Subject: LU/62/21/L

LU/62/21/L

13 South Terrace Littlehampton BN17 5NZ

Listed building consent for works to renew mortar flashing with lead flashing, re-pint to brick work & repair cornice/dental course to front, replace 3 No windows to top floor, repair & refurbish 9 No. wooden sash windows, replace canopy & refurbish/repaint balcony, repair & refurbish 2 No. set of wooden balcony doors, replace skirting board in lower ground floor, render & repair to front brick & rear flint walls, refurbish/repaint front door entrances to lower ground floor, repair front brickwork, re plaster & paint front entrance & hallway, remove toilet front utility room on lower ground floor & re-tile top floor bathroom & add shower unit, reform lower ground floor steps & refurbish & repaint both front door entrances on lower ground & ground floor.

13 South Terrace Floor 2

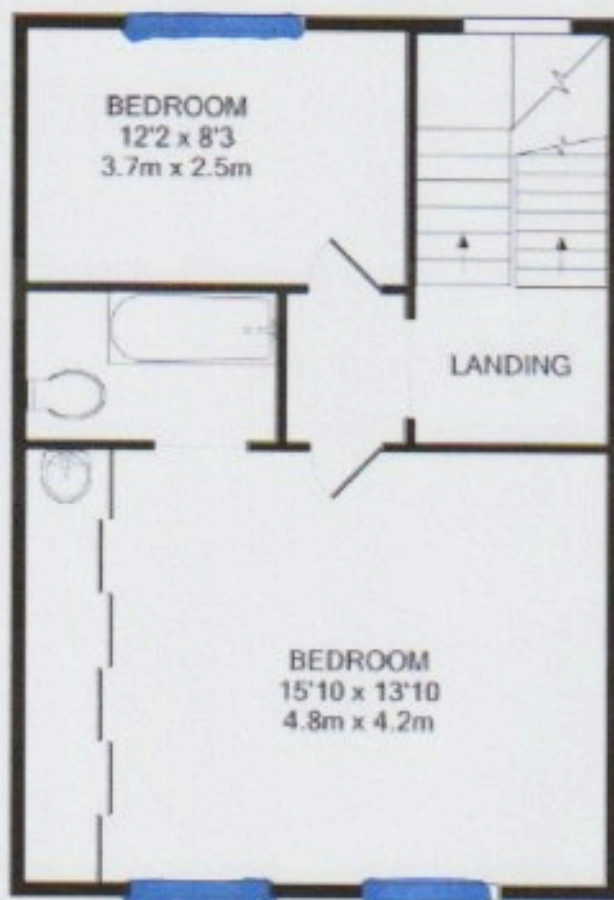
Likewise, it is not clear what the replacement windows will look like, and I am concerned with references to the presence of double glazing (this would have required consent). Further details of the proposed replacement windows are required.

13 South Terrace Floor 1

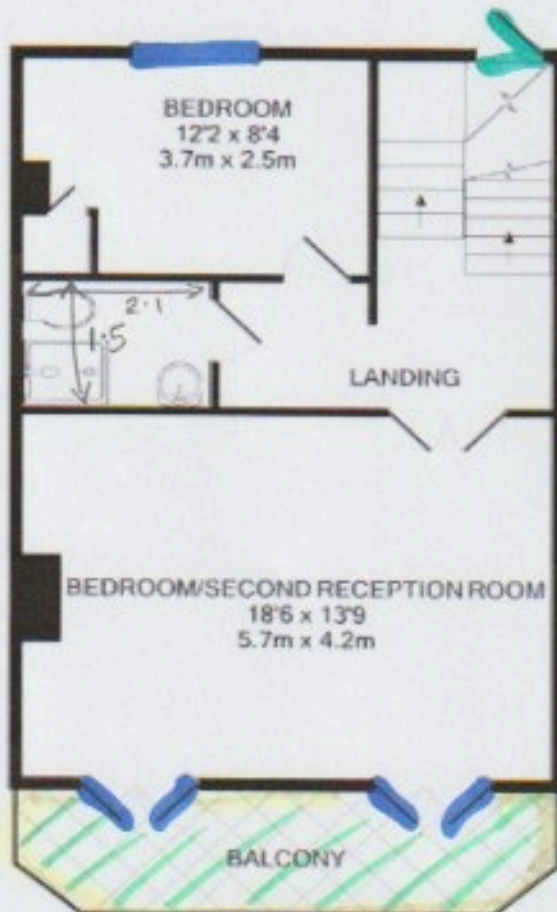
The works to the balcony indicate that the felt covered canopy needs replacing and the structure of the balcony needs refurbishing/repainting. However, it is not clear what materials will be used on the roof or what kind of works are required to refurbish the balcony. For instance, will the railings be replaced, and if so, what with? Also, will the paint colour remain the same or change? If it will change, what colour is proposed?
